**Date:** 05/14/2023

**Re:** **Framing Issue**  
Location: Lot 4 Griffon Pointe (24 Drathaar Ct. (Lillington, NC))  
JDS Project No.: RDU2303522  
Date of Inspection: 05/11/2023

A representative of JDS Consulting arrived on site to observe the issues reported to us by the client, which are presented, along with our recommendations, in this report.

SHEET NO.  
S3

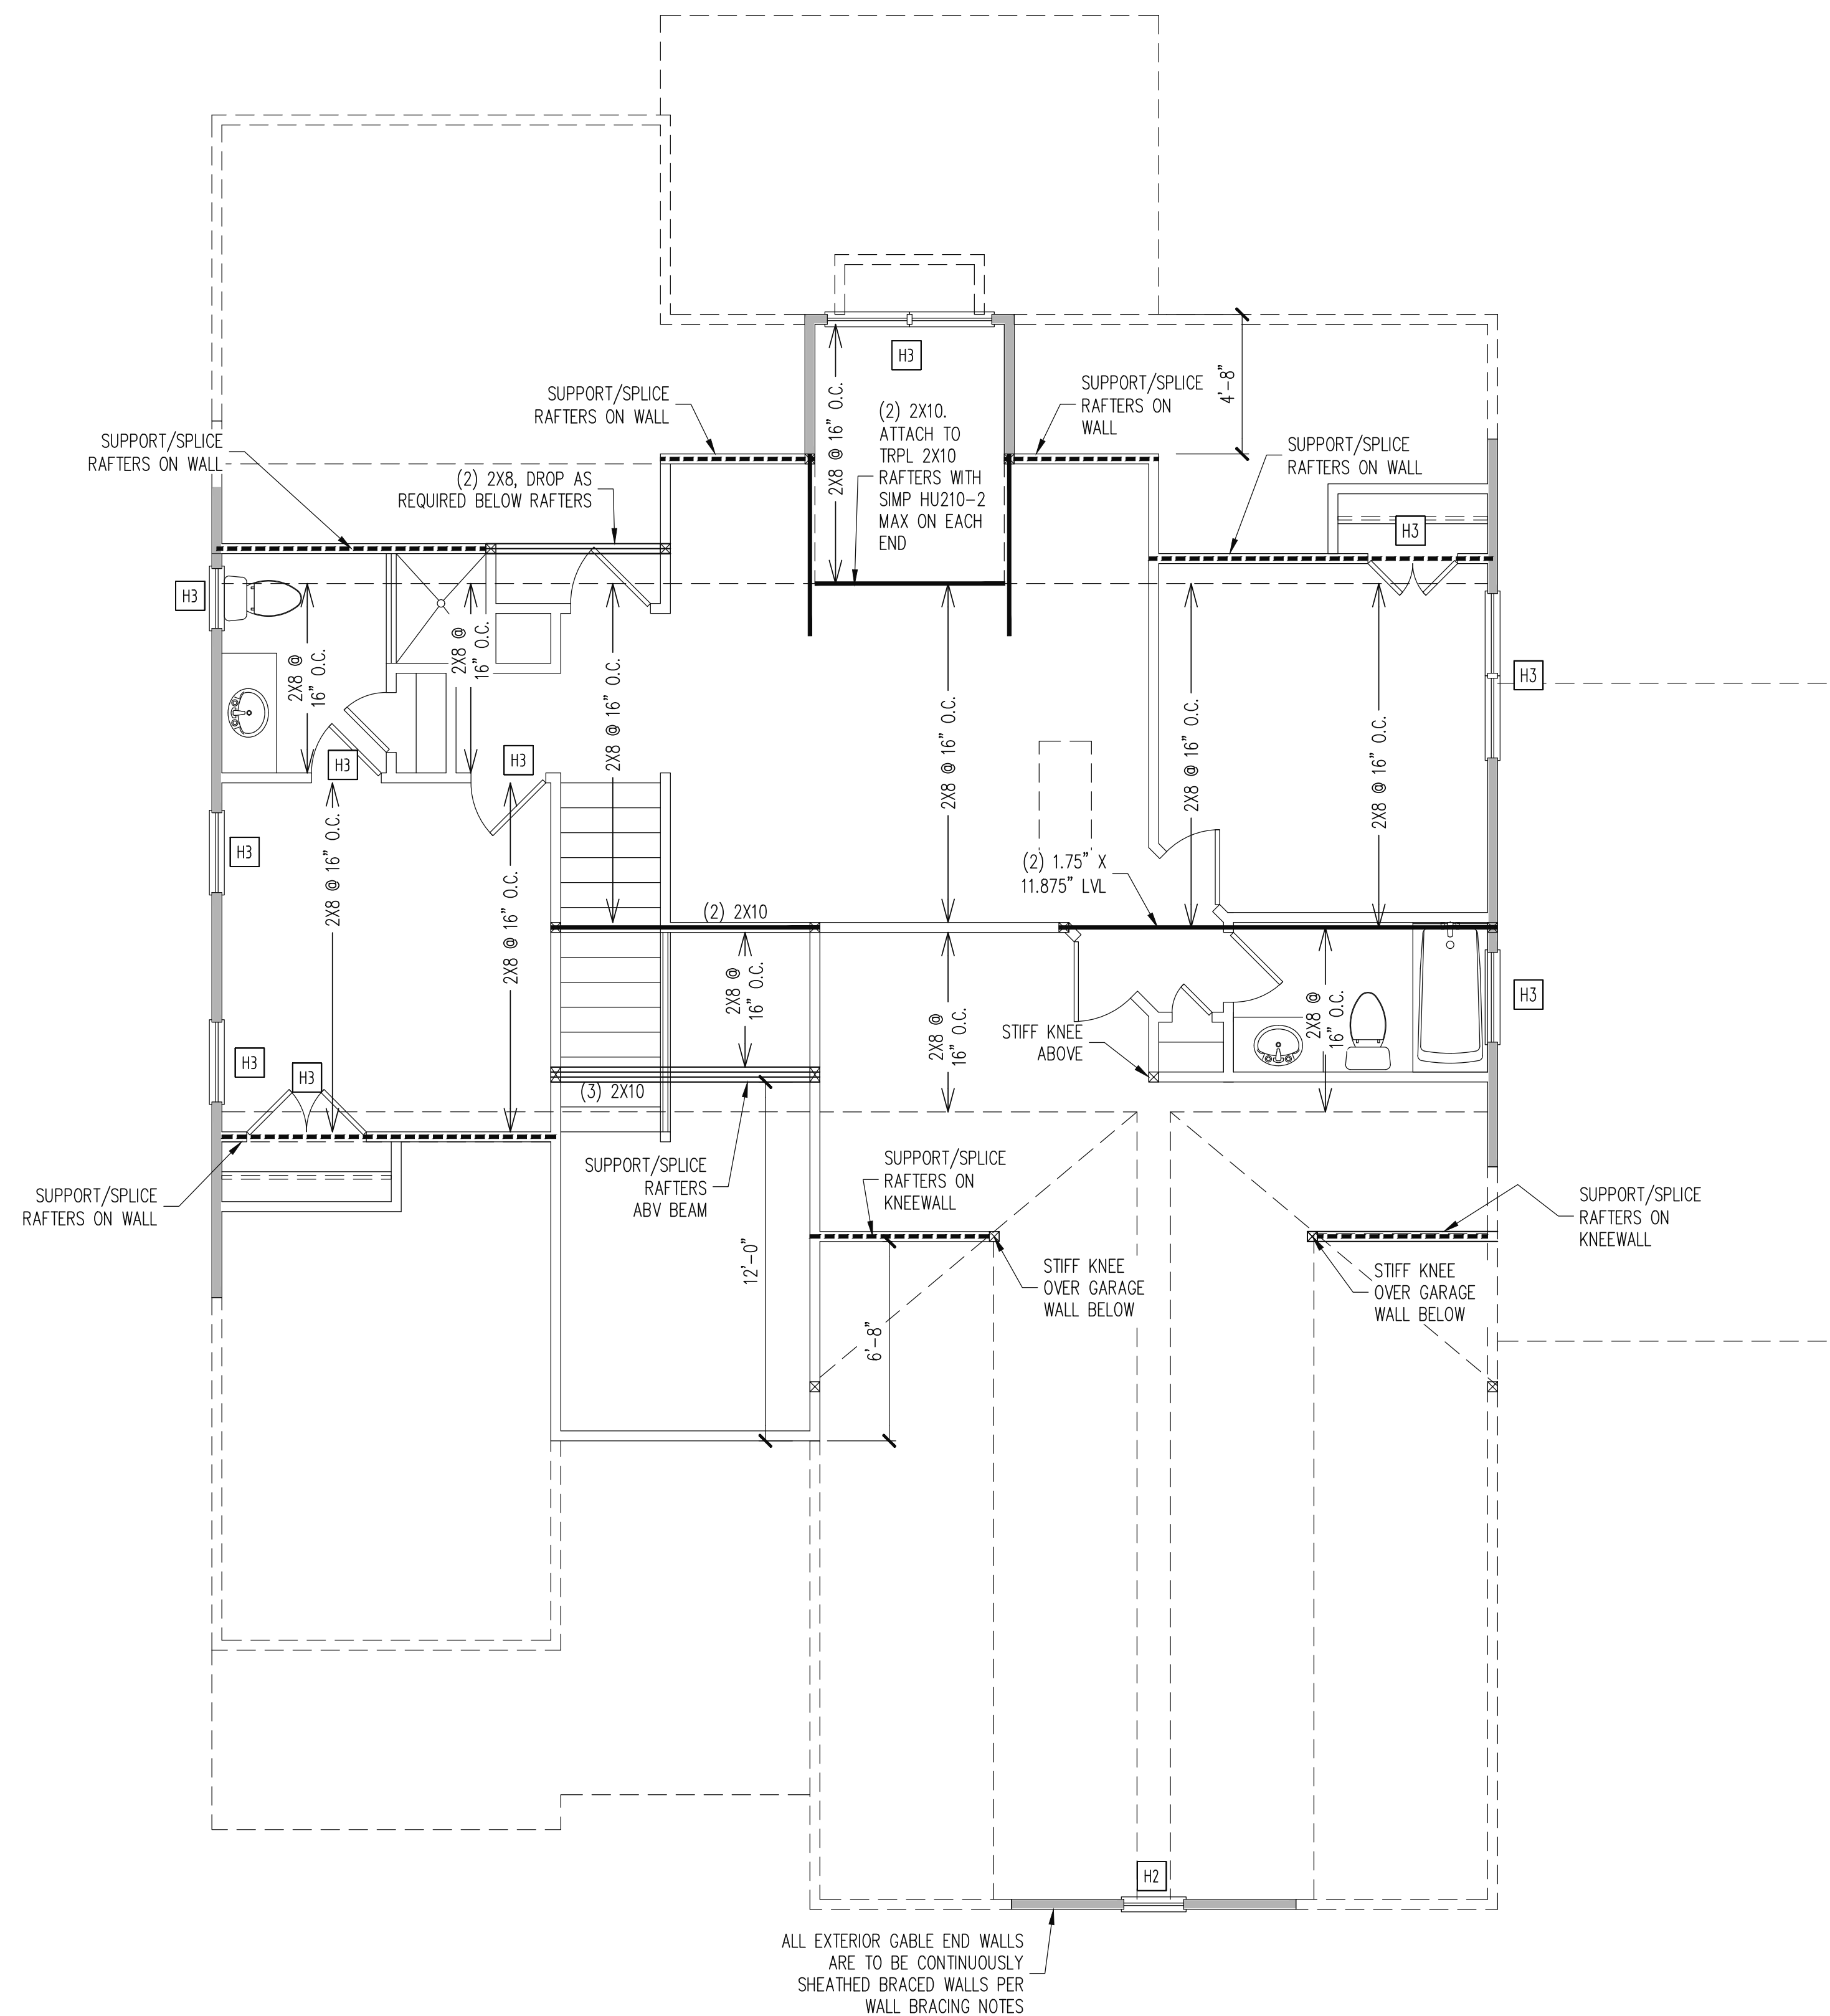
4. The contractor installed the 2x8 vaulted rafter bearing at the 2x6 front wall above the foyer instead of installing a (2) ply 1-3/4"x 9-1/4" LVL per sheet S3 of the building plans to support the rafters mentioned above.

1. The 2x10 ridge is adequate to support the loading conditions provided the 2x rafters are fully supported into the ridge. No further action is required.
2. The LVL valley has a sufficient bearing area for the loading conditions. No further action is required.
3. The 2x10 ridge is sufficient for the loading conditions, however, where the 2x8 rafters are not fully bearing into the ridge, the contractor shall install furr out the ridge with 2x material to provide full support for the full depth of the 2x8 rafters. The ridge depth shall be not less than the cut end of the 2x8 rafters.
4. The 2x8 vaulted rafters bearing into the 2x6 front wall of the foyer are adequate. No further action is required.

**SHEET NO.**  
**S5**

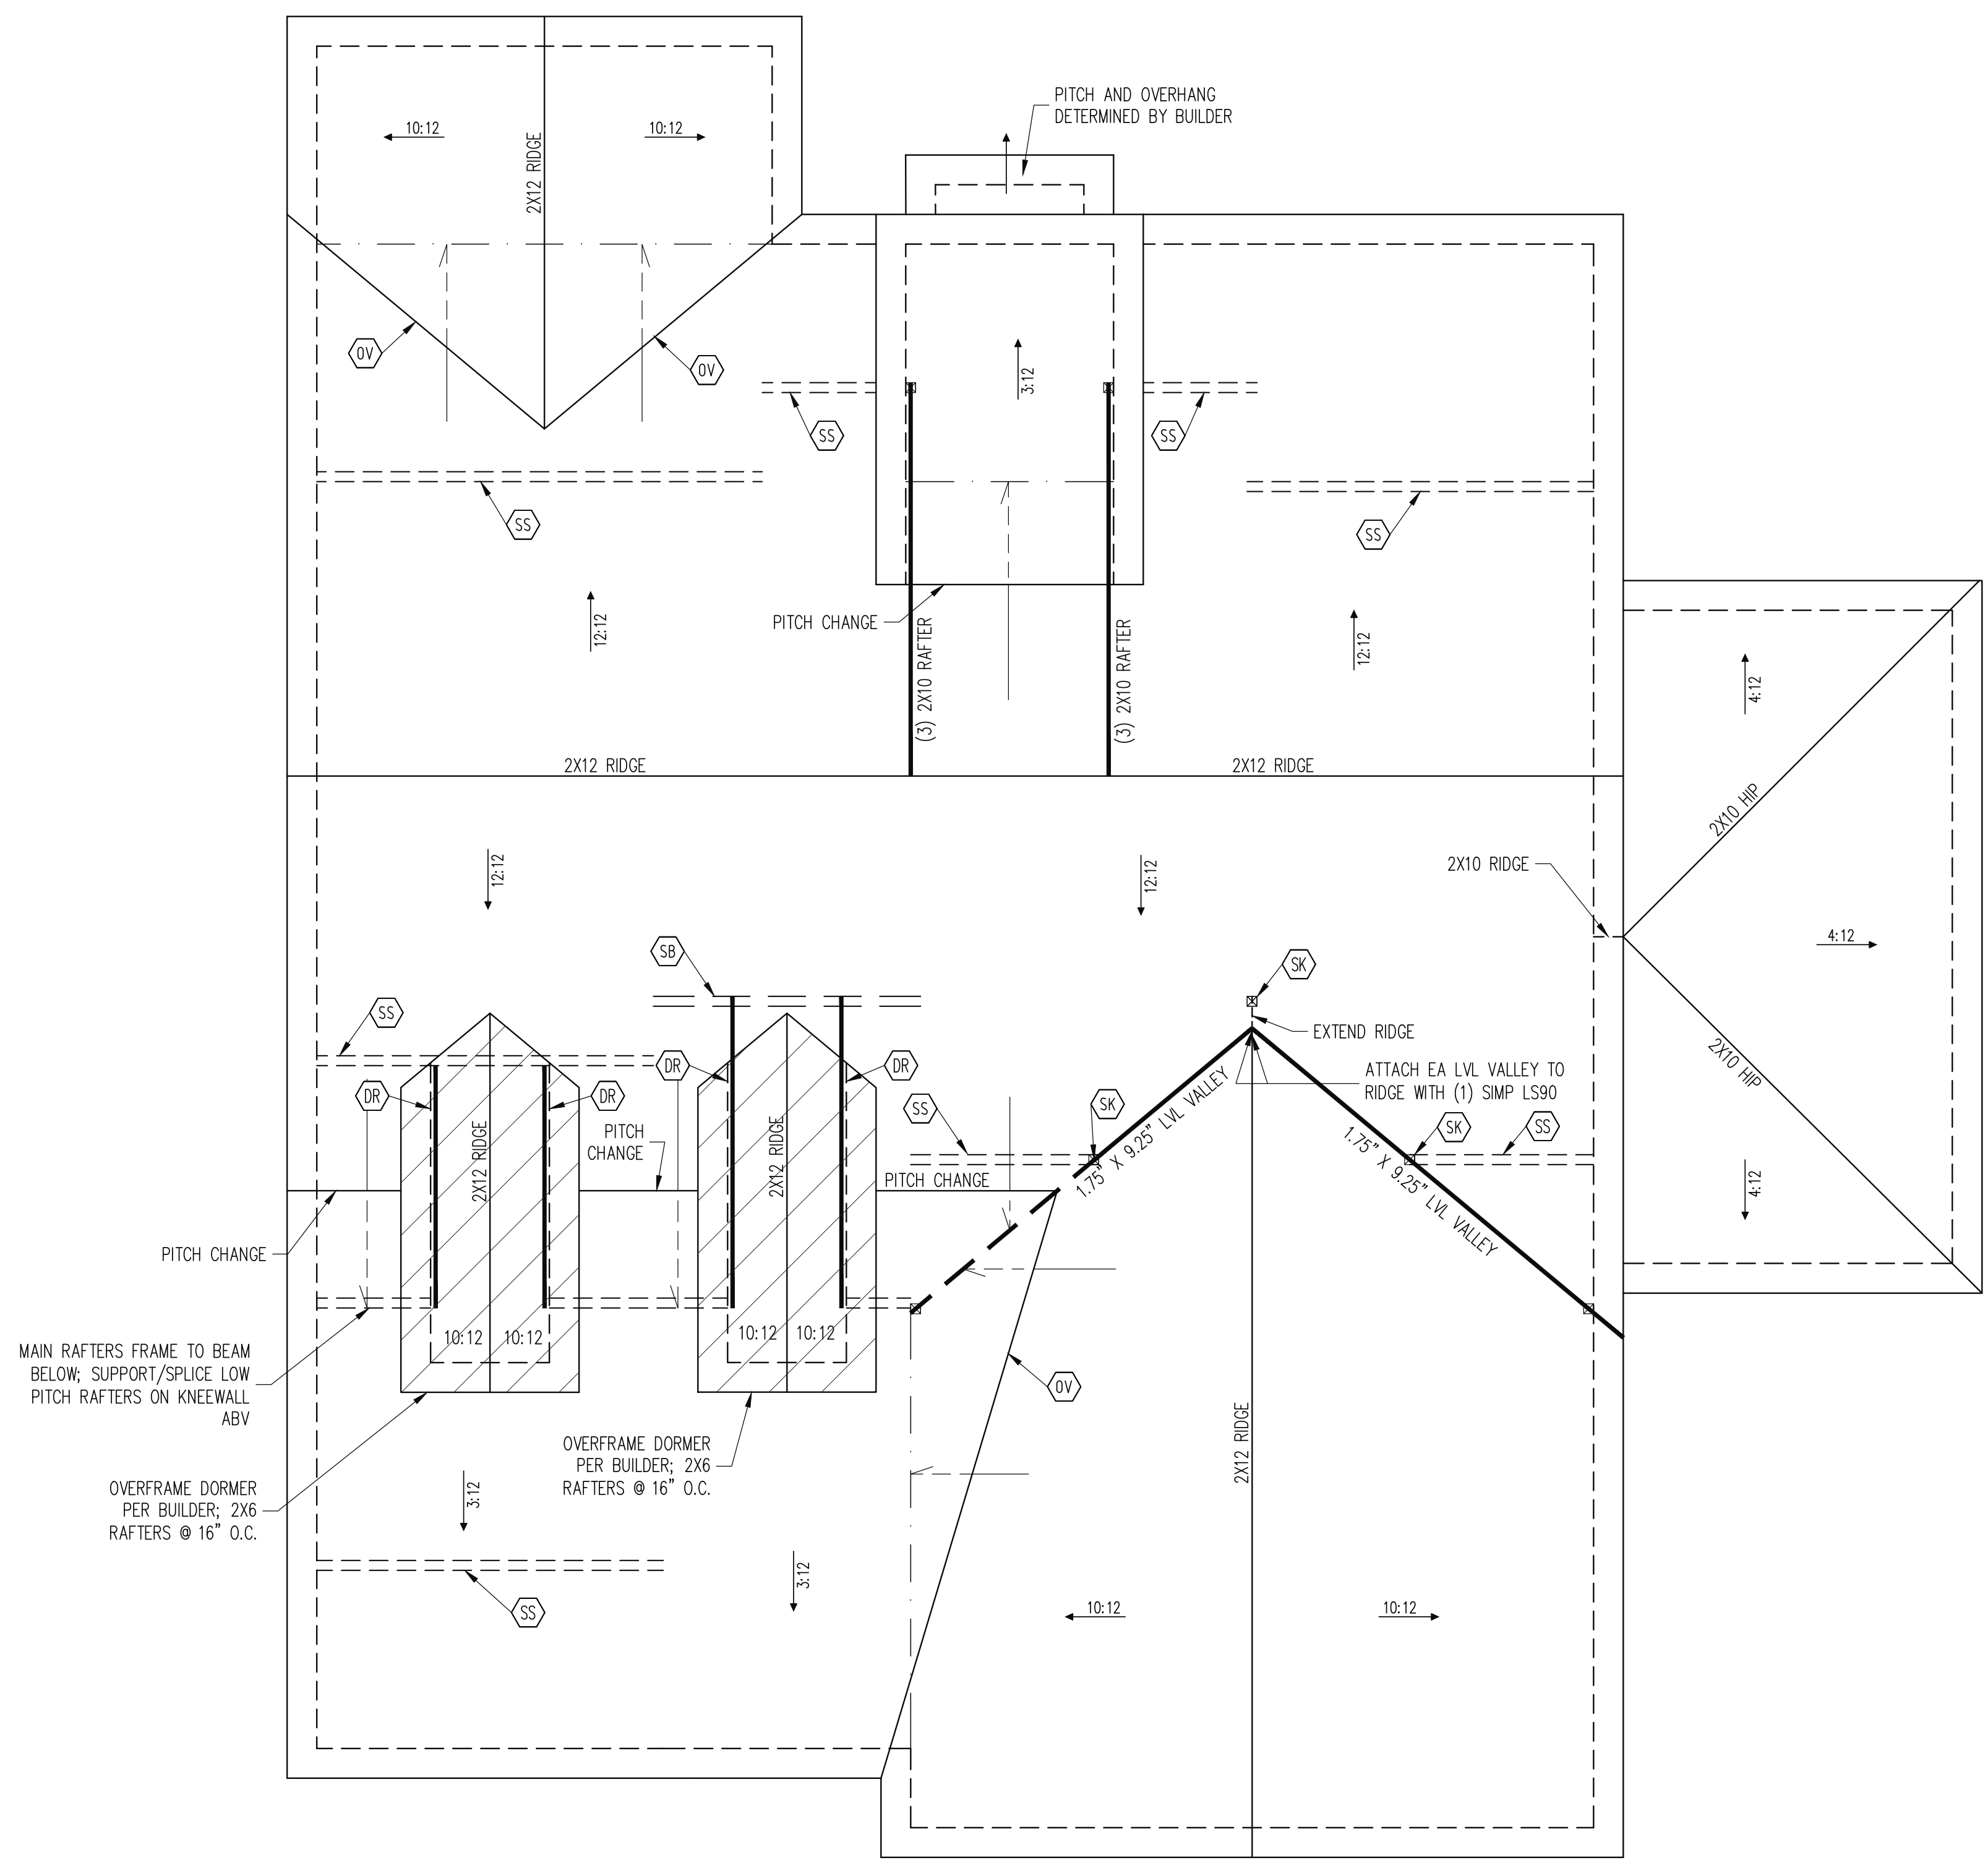
1. The contractor installed a 2x10 ridge above the main roof supporting 2x8 rafters with (1) 2x6 collar ties spaced 32" o.c., and installed 2x material beneath the ridge attached with nails into the 2x10 ridge to fully support the 2x8 rafters instead of installing 2x12 ridge beam per sheet S5 of the building plans.

3. The contractor installed a section of 9'-0" long 2x10 ridge beam spanning front to back from the rear side of the ridge above the attic instead of installing a 2x12 ridge per sheet S5 of the building plans.
